City of Portland, Maine - Building or Use Permit Application

Permit No: 02-1361	Issue Date: JAN - 3 - 2003	EBL: 376 A055001
-----------------------	--------------------------------------	---------------------

Location of Construction: 3-9 Farm House Ln (Lot #5)	Owner Name: Leslie Gordon D &	Owner Address: 1757 Washington Ave	Phone: 329-9723
Business Name: n/a	Contractor Name: Frank D. Grondin Builders	Contractor Address: 5 Webster Road Freeport	Phone: 2072337930
Lessee/Buyer's Name n/a	Phone: n/a	Permit Type: Single Family	Zone: R-3

02-1361

FRONT ELEVATION  
Scale: 1/4" = 1'-0"

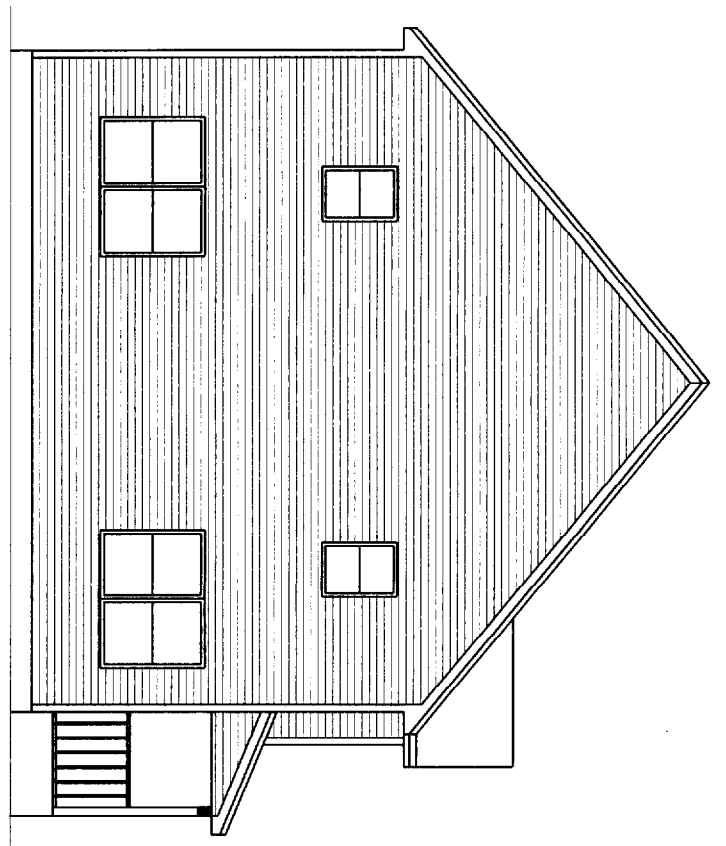
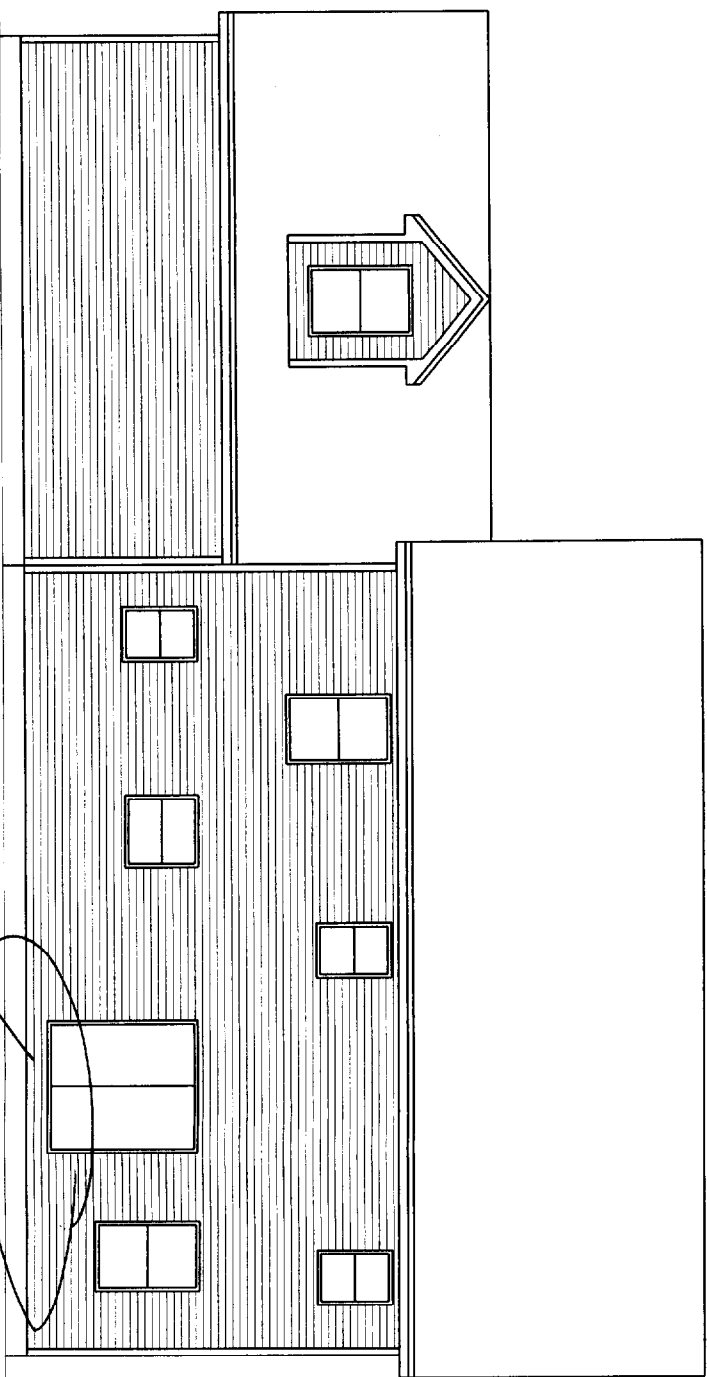
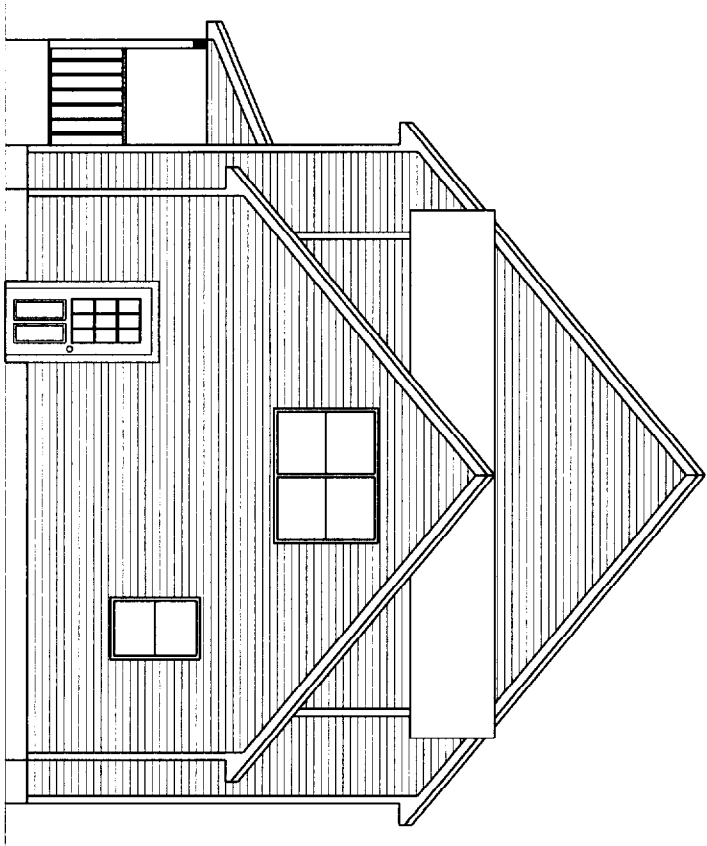
Dept: Zoning	Status: Approved with Conditions	Reviewer: Marge Schmuckal	Approval Date: 12/23/2002
Note: 3-9 Farm House Lane (lot #5)			Ok to Issue: <input checked="" type="checkbox"/>
1) Separate permits shall be required for future decks, sheds, pools, and/or garages. NO REAR DECKS were shown on any submitted plans, therefore, NO REAR DECKS have been approved.			
2) This permit is being approved on the basis of plans submitted. Any deviations shall require a separate approval before starting that work.			
Dept: Building	Status: Pending	Reviewer:	Approval Date:
Note:			Ok to Issue: <input type="checkbox"/>

FOUNDATION PLAN  
Scale: 1/4" = 1'-0"

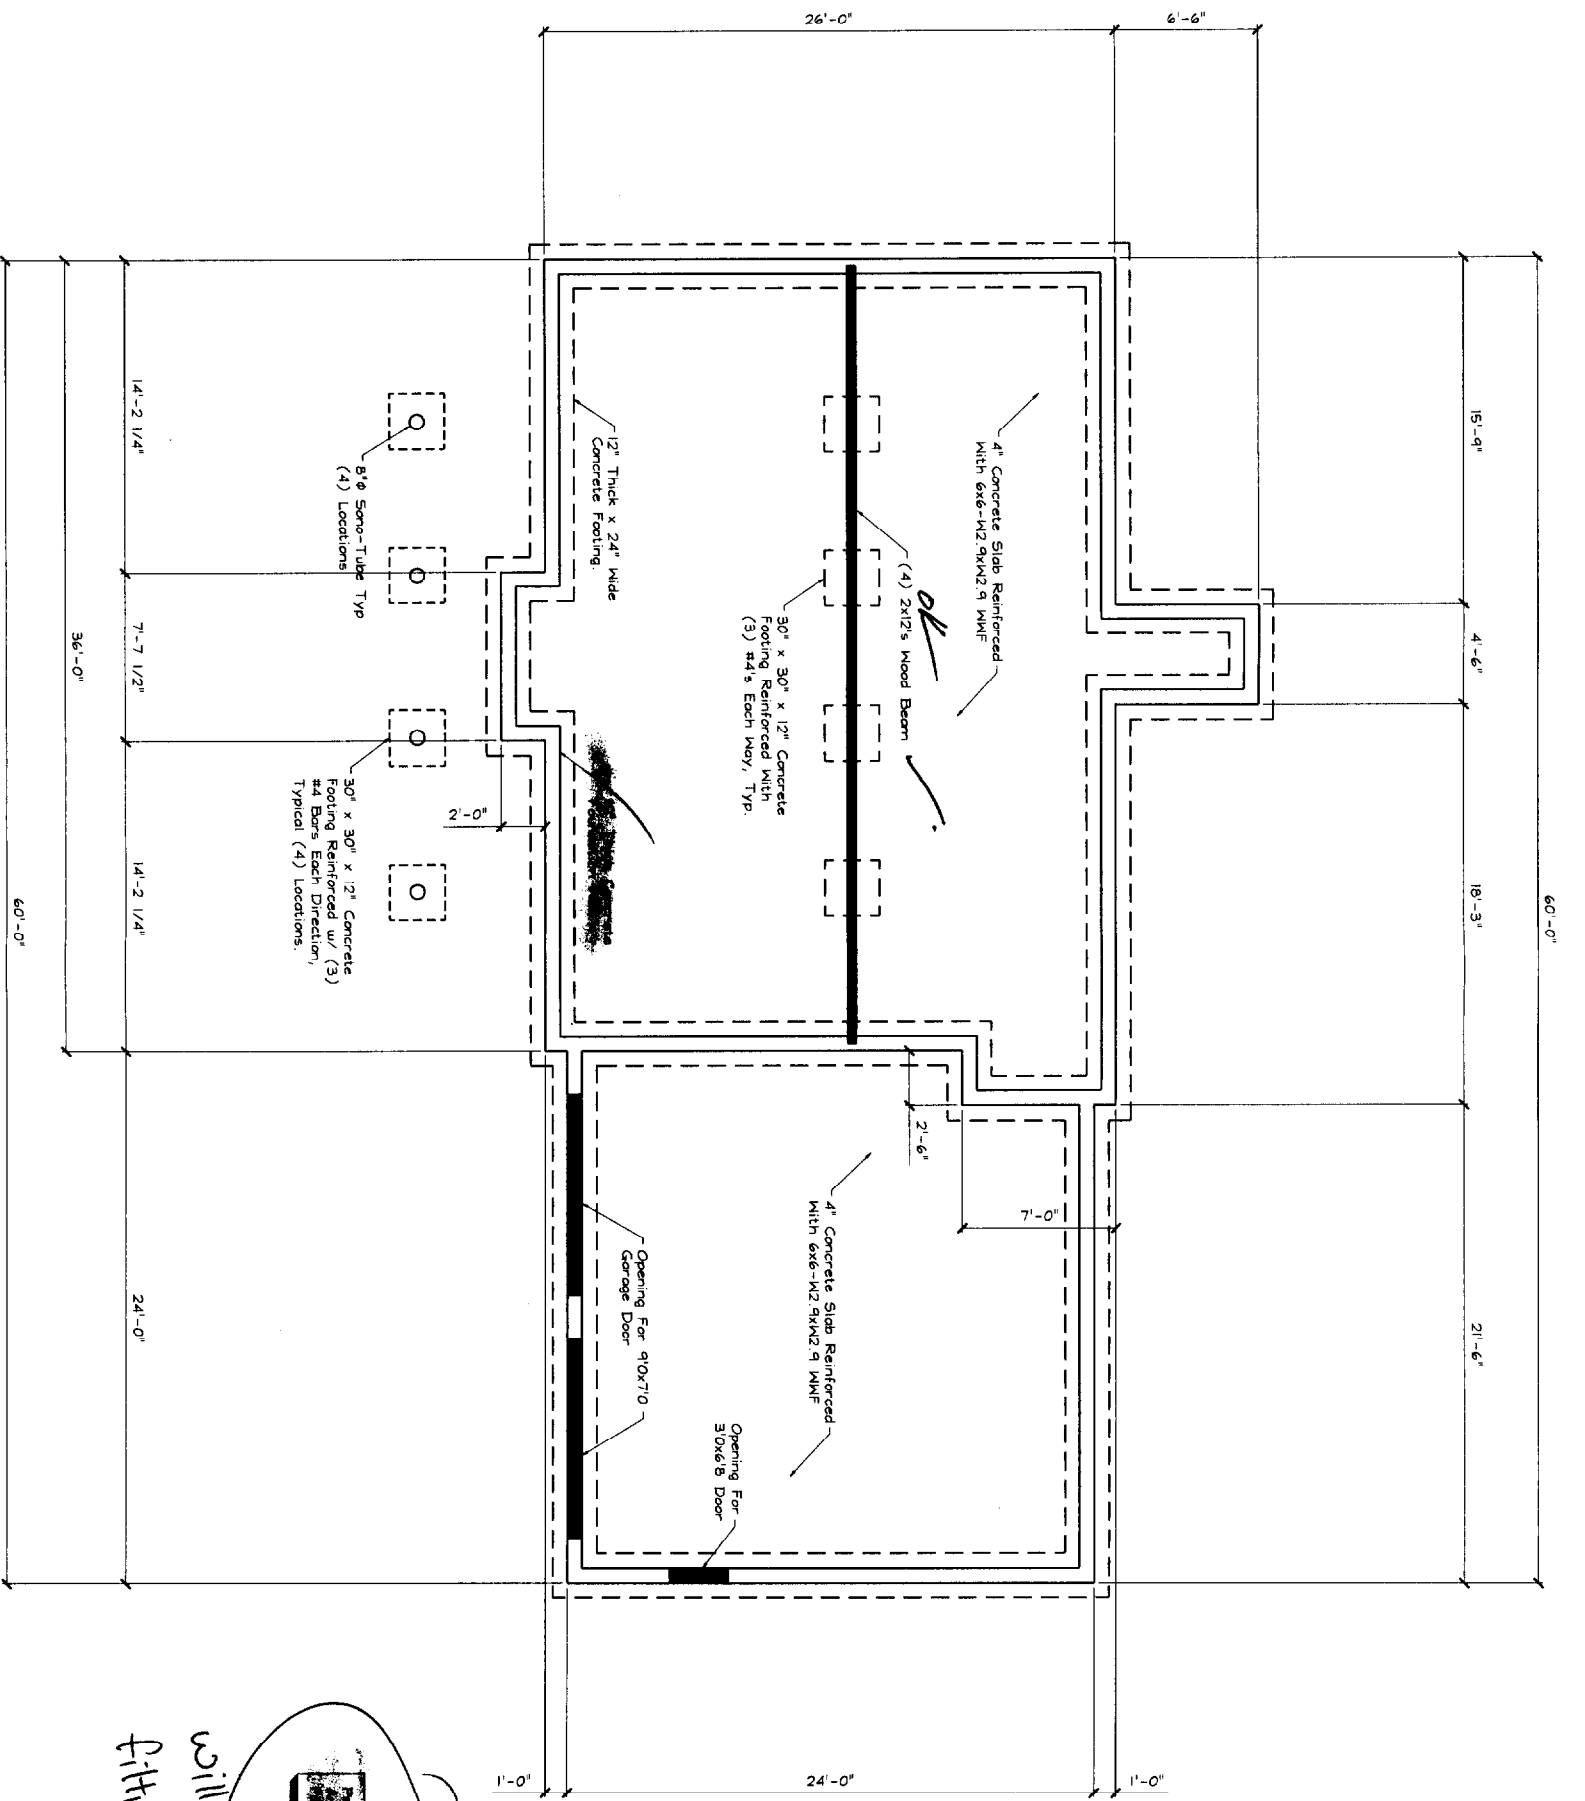
Soil type/Presumptive Load Value (Table 401.4.1)	Component	Plan Reviewer	Inspection/Date/Findings
STRUCUTRAL Footing Dimensions/Depth (Table 403.1.1 & 403.1.1(1), Section 403.1.2)	Foundation Drainage Dampproofing (Section 406)	D/A	Not shown OK OK
Lally Column Type, Spacing and footing sizes (Table 502.3.4(2))	Built-Up Wood Center Girder Dimension/Type (Table 502.3.4(2))	OK	OK
First Floor Joist Species Dimensions and Spacing (Table 503.3.1(1) & Table 503.3.2(1))	Sill/Band Joist Type & Dimensions	OK	OK
Second Floor Joist Species Dimensions and Spacing (Table 503.3.1(1) & Table 503.3.2(1))		OK

Note: Provide Draft Stopping Around Chimney At Each Floor. Provide Smoke Detectors On Each Floor, Every Bedroom, And All Hallways.

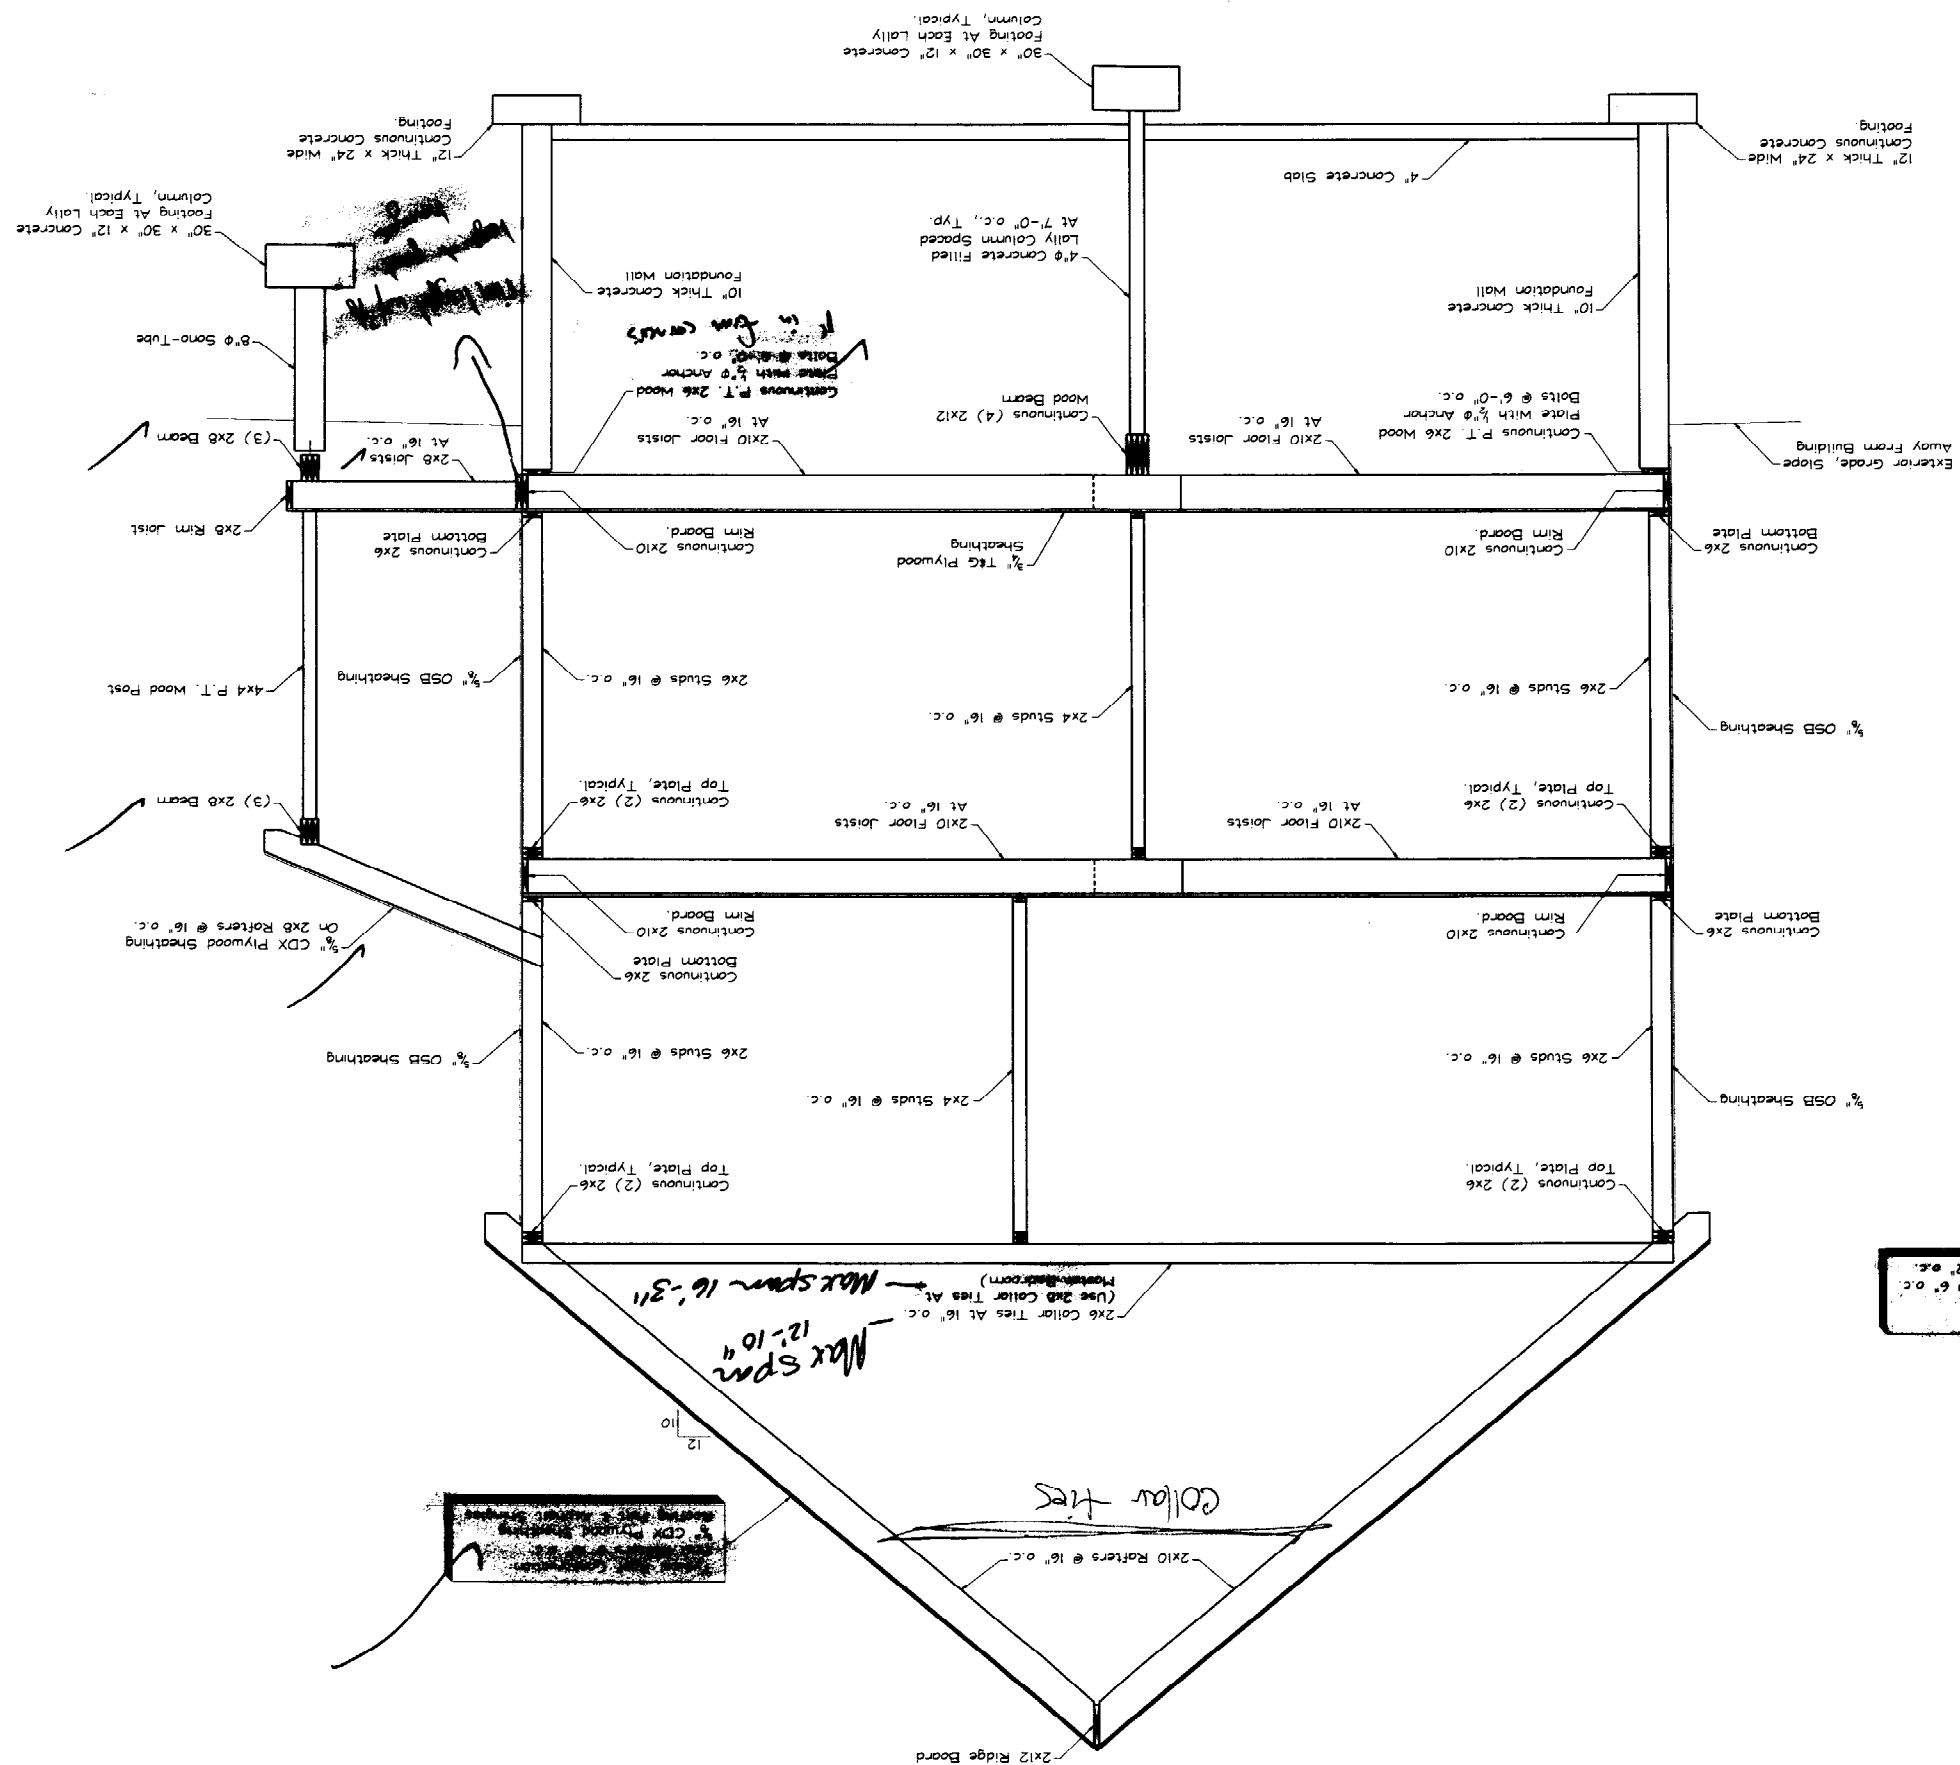
Attic or additional Floor Joist Species Dimensions and Spacing (Table 802.4.2 or 503.3.1(1) & Table 503.3.2(1))	2x6-5 NOT adequate	OK
Roof Rafter; Pitch, Span, Spacing & Dimension (Table 802.3.2(7))	OK	OK
Sheathing; Floor, Wall and roof (Table 503.2.1(1))	OK	OK
Fastener Schedule (Table 602.3(1) & (2))	Not shown	OK
Private Garage Section 309 and Section 407 1999 BOCA) Living Space? YES - Above + (Above or beside) Beside Fire separation	Not shown	OK
Fire rating of doors to living space Door Sill elevation (407.5 BOCA)	Not shown	OK
Egress Windows (Section 310)	Not shown	OK
Roof Covering (Chapter 9)	Not shown	OK
Safety Glazing (Section 308)	Not shown - need safety in bath	OK
Attic Access (BOCA 1211.1)	Not shown	OK
Draft Stopping around chimney	" "	OK
